339-D-009001

Barclay Avenue Lot Division  
Project Name/Description

Memorandum  
Department of Planning and Development  
Planning Division

Re: Barclay Avenue Three Lot Subdivision, vicinity 35 Barclay Avenue  
APPENDUM #1

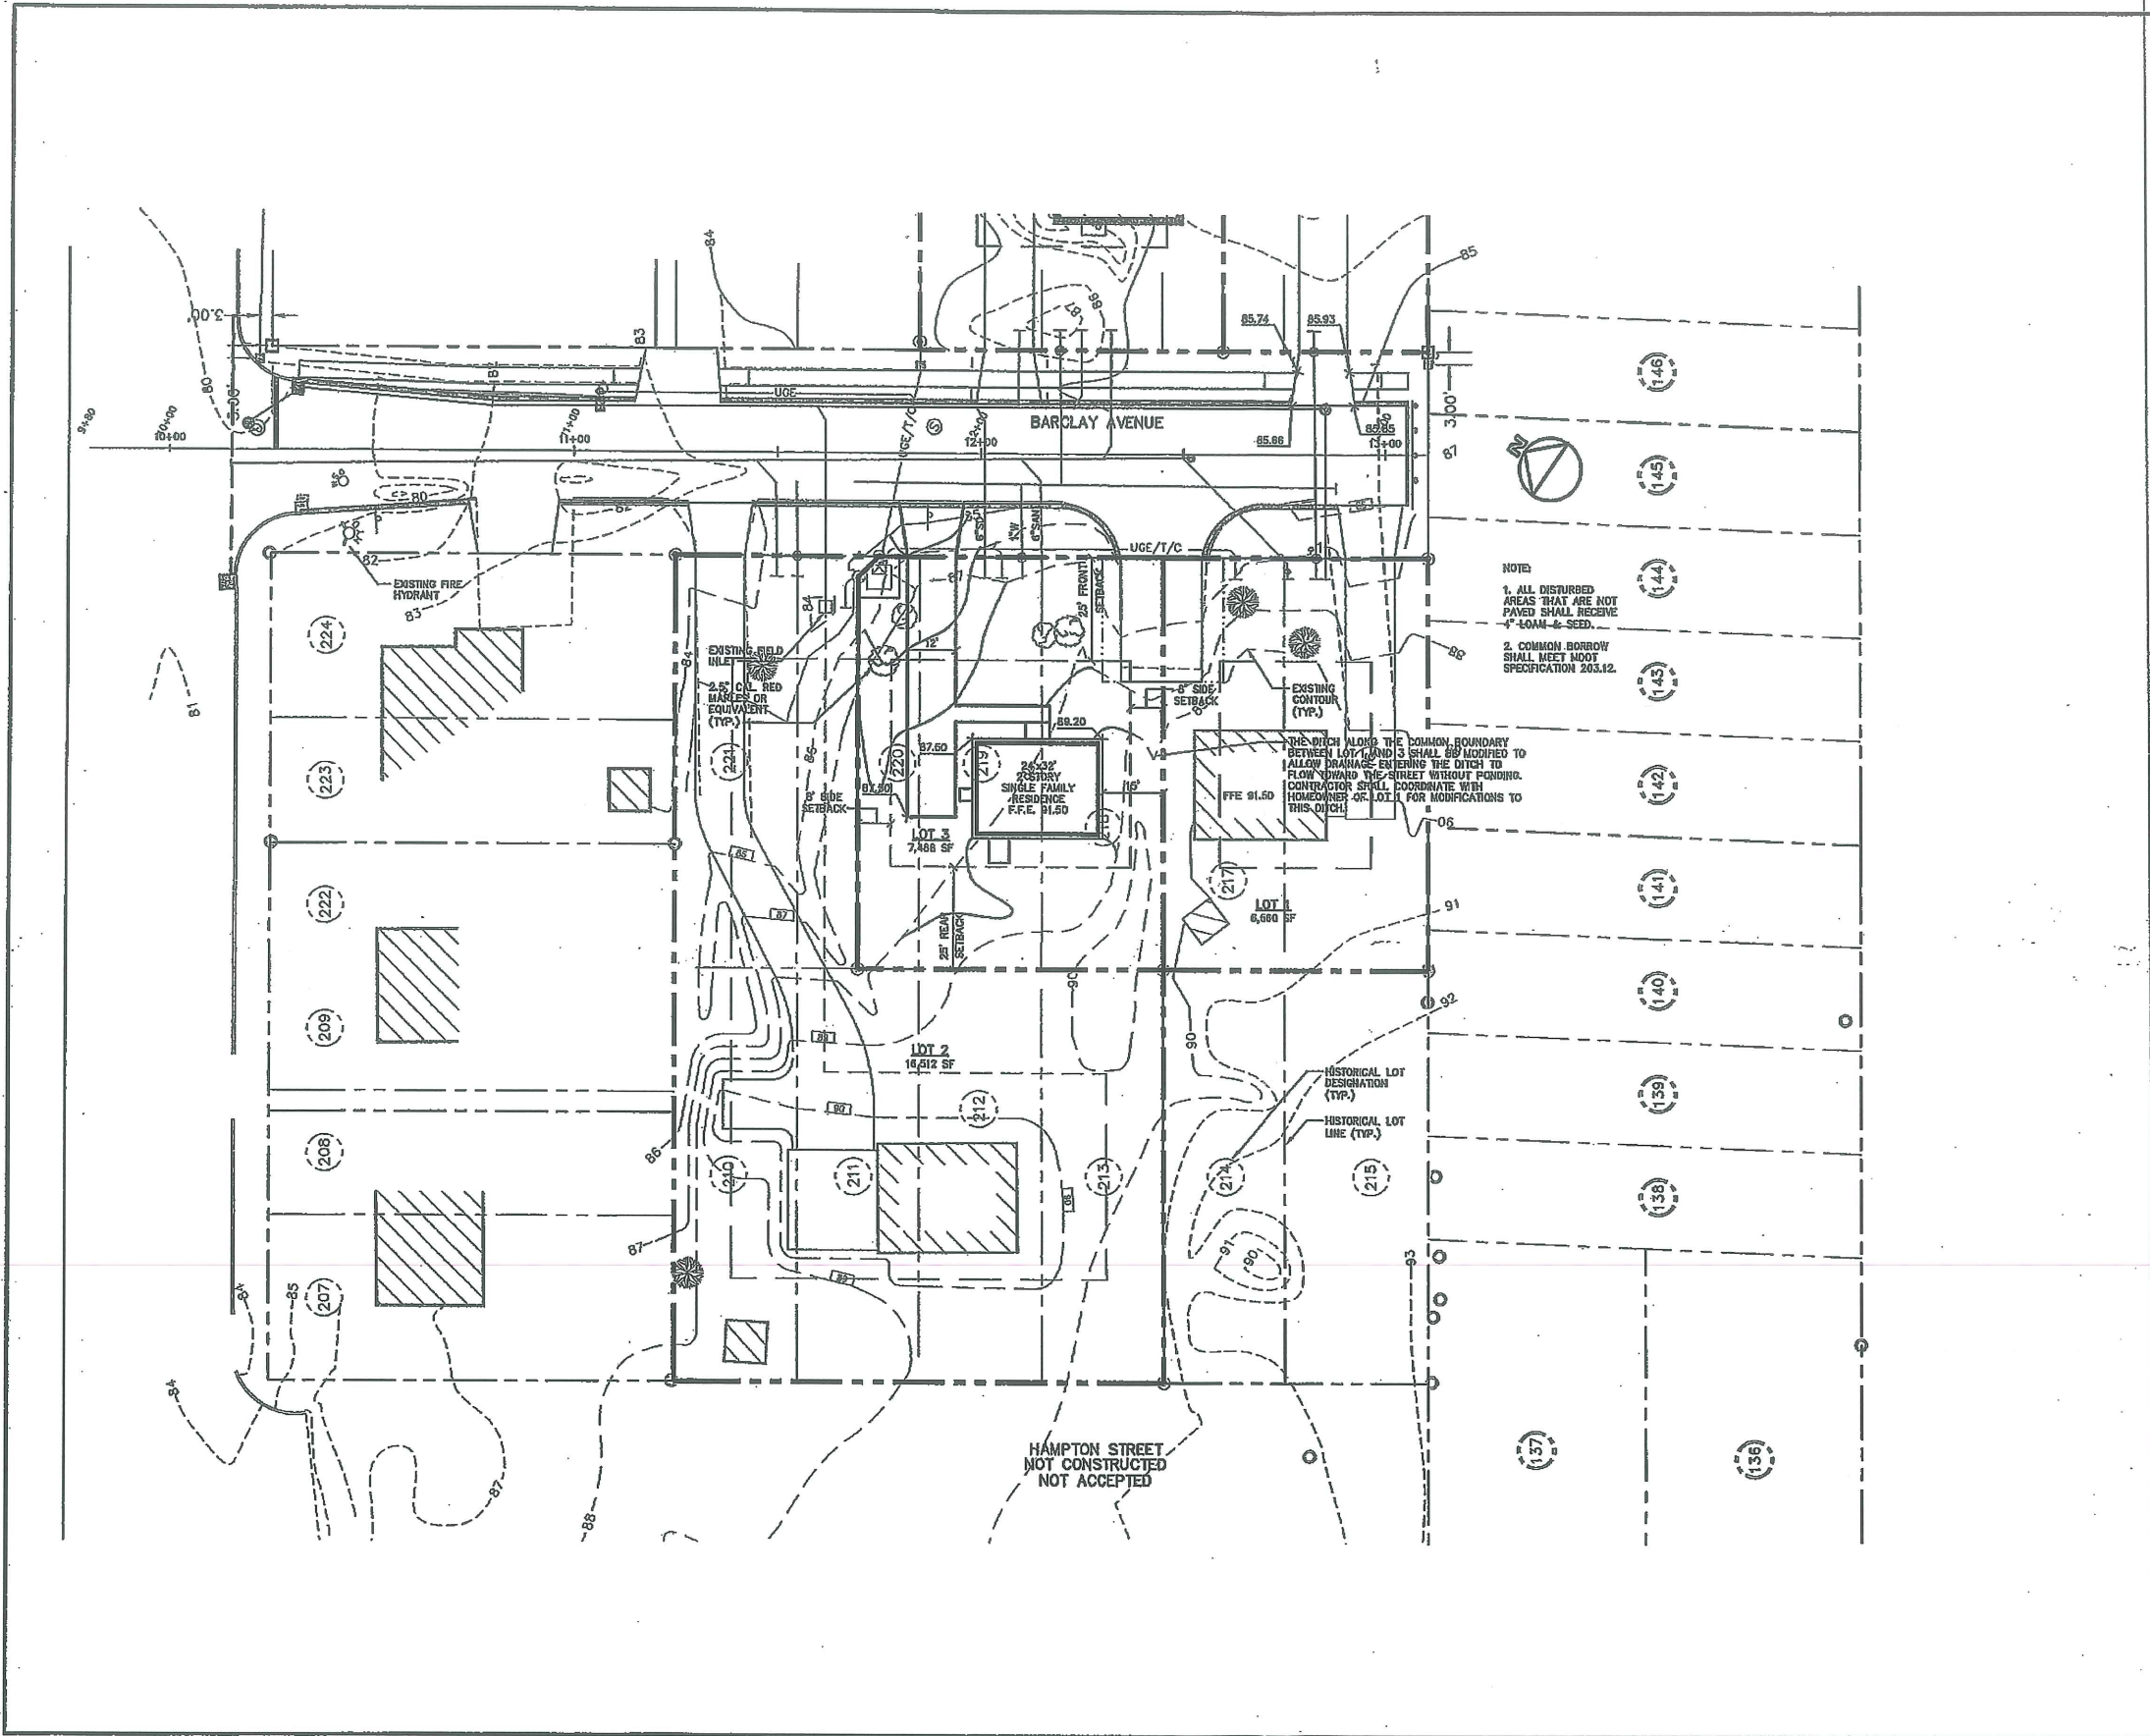
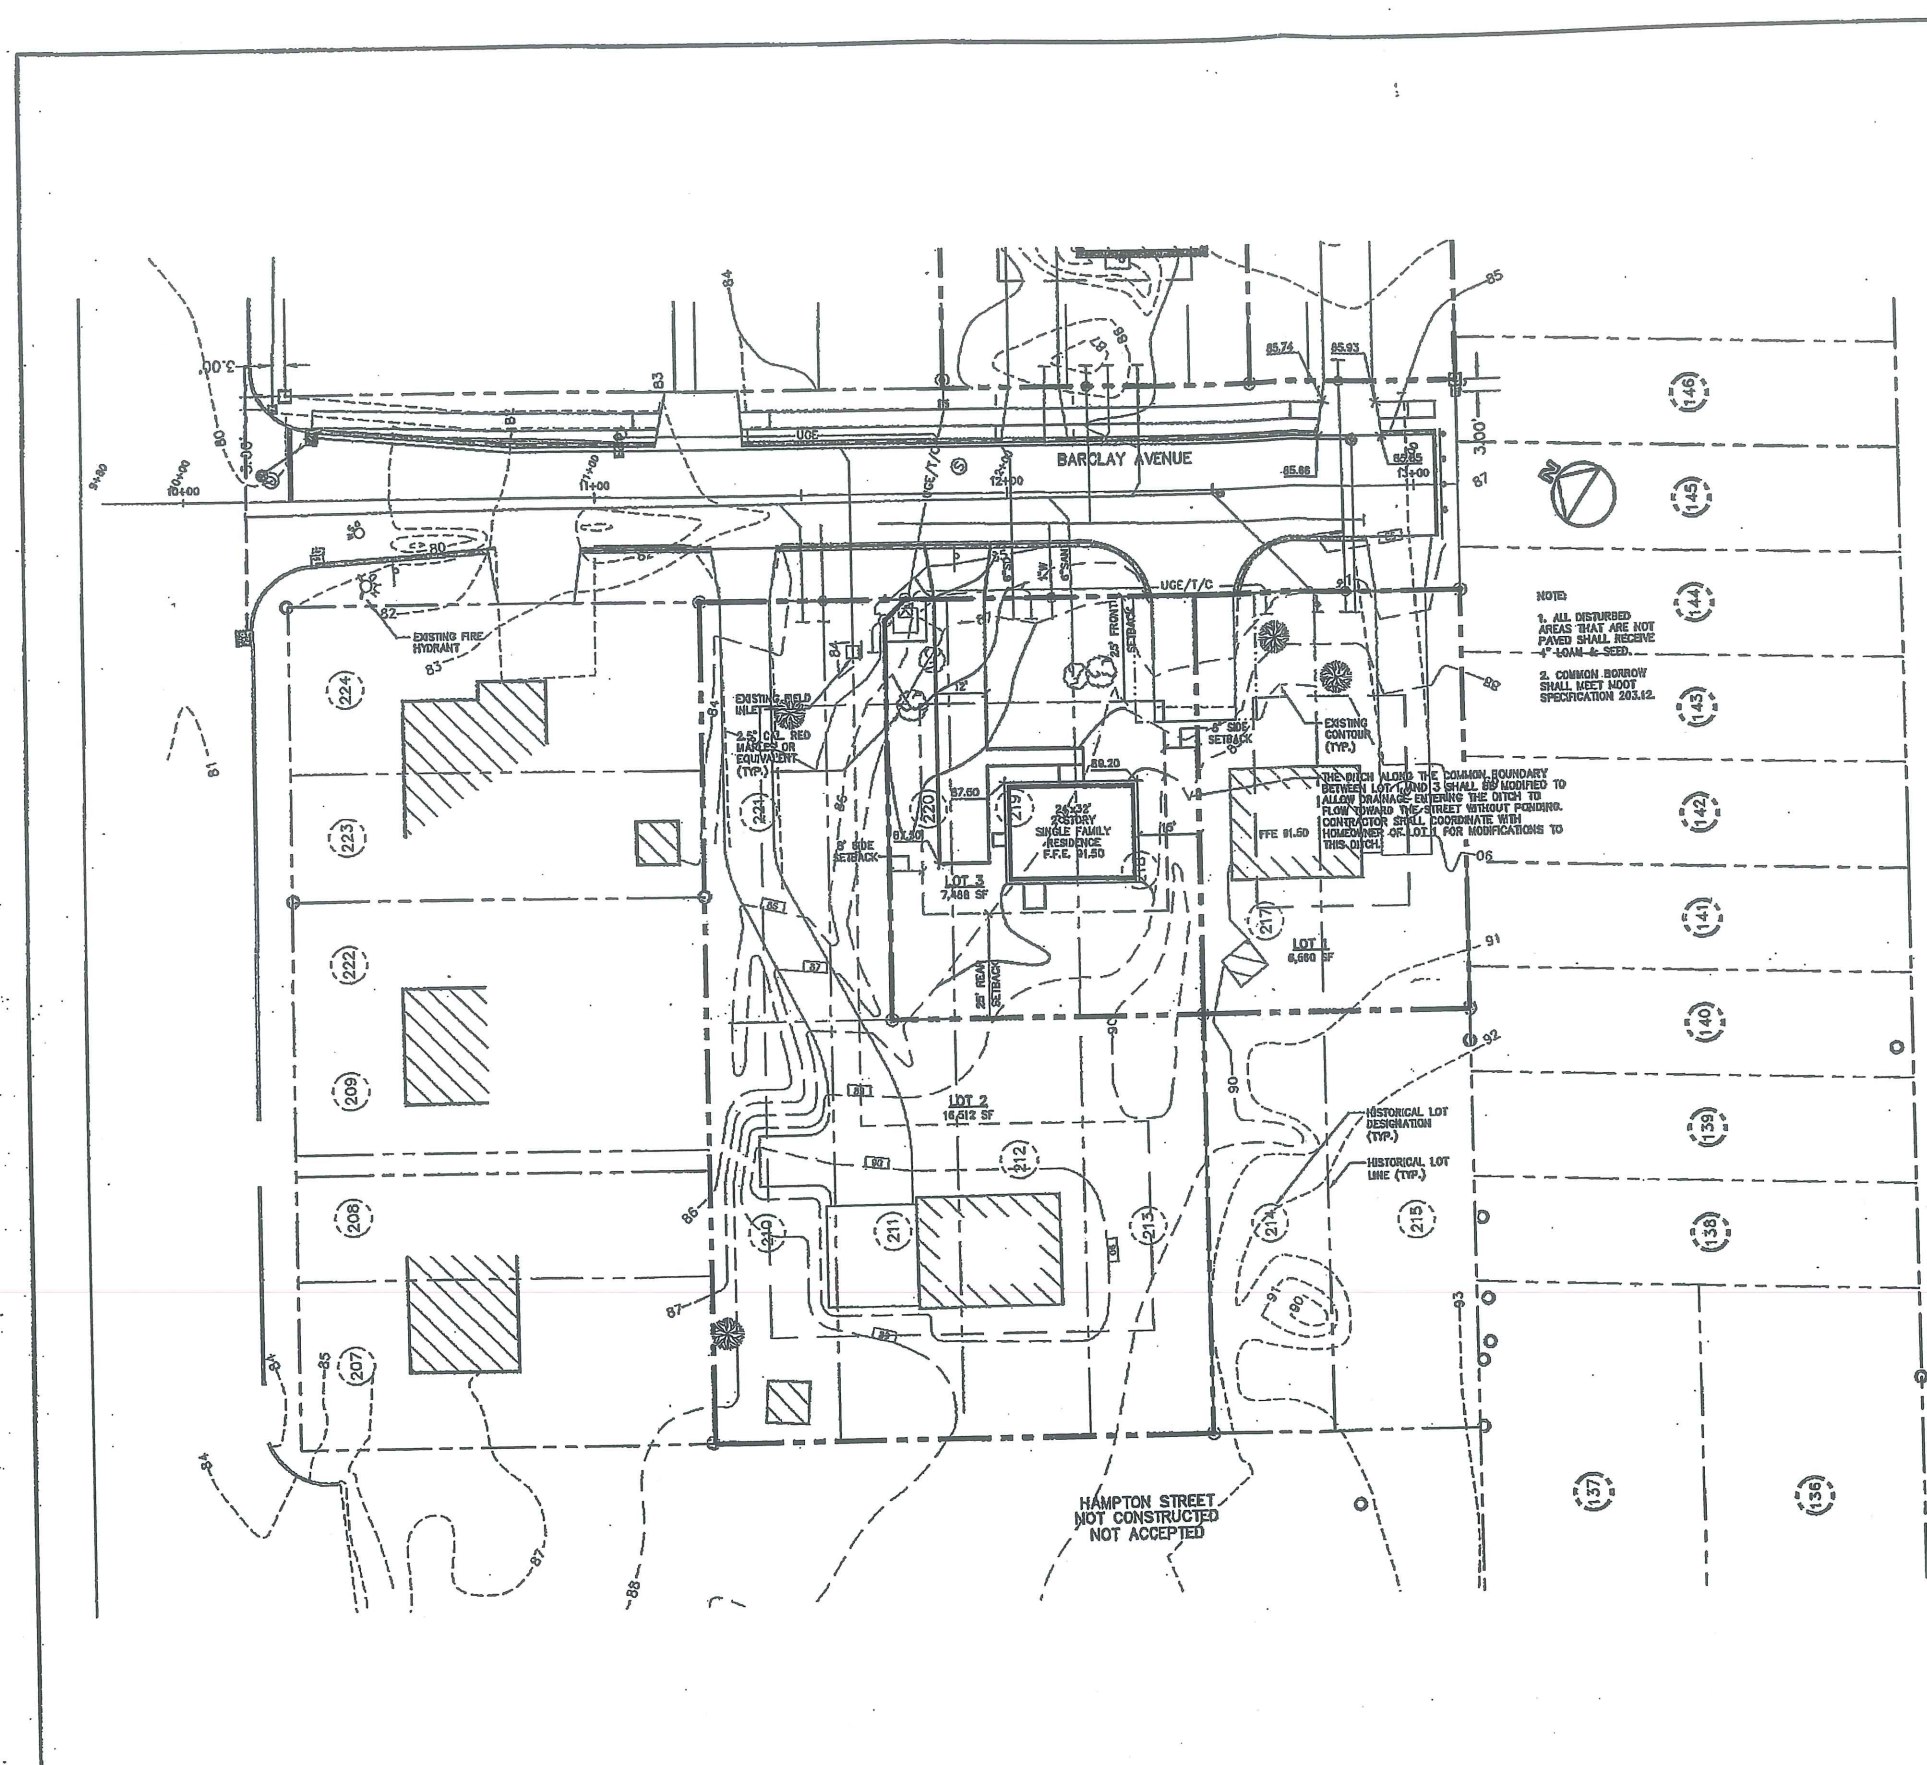
- i. The Subdivision Plat will be finalized to the satisfaction of the Corporation Counsel and shall include reference to the drainage all easements, Performance Guarantee and relevant conditions; and

- iii. The applicant shall secure, submit for review and approval by Corporation Counsel, and show on the Subdivision Plat, an executed construction easement for the ditch area between Lots 1 and 3; and

2. There is one tree to the right rear of my lot (just behind my shed) that I would like to be saved. It is inside my property line, but may have some branches that hang onto the

2) A condition that the builder/developer be required to save the tree that I have mentioned above.

vii - add like tree on lot 1 'no cut' 10x10.

VII That a 10x10 area in the south<sup>ly</sup> of  
lot 3 shall be retained primarily <sup>deducted from</sup> parking  
interior w/ tree on lot #1 and no parking or  
other except for disease, damage disease,  
damage or injury as result of a/h limbs.
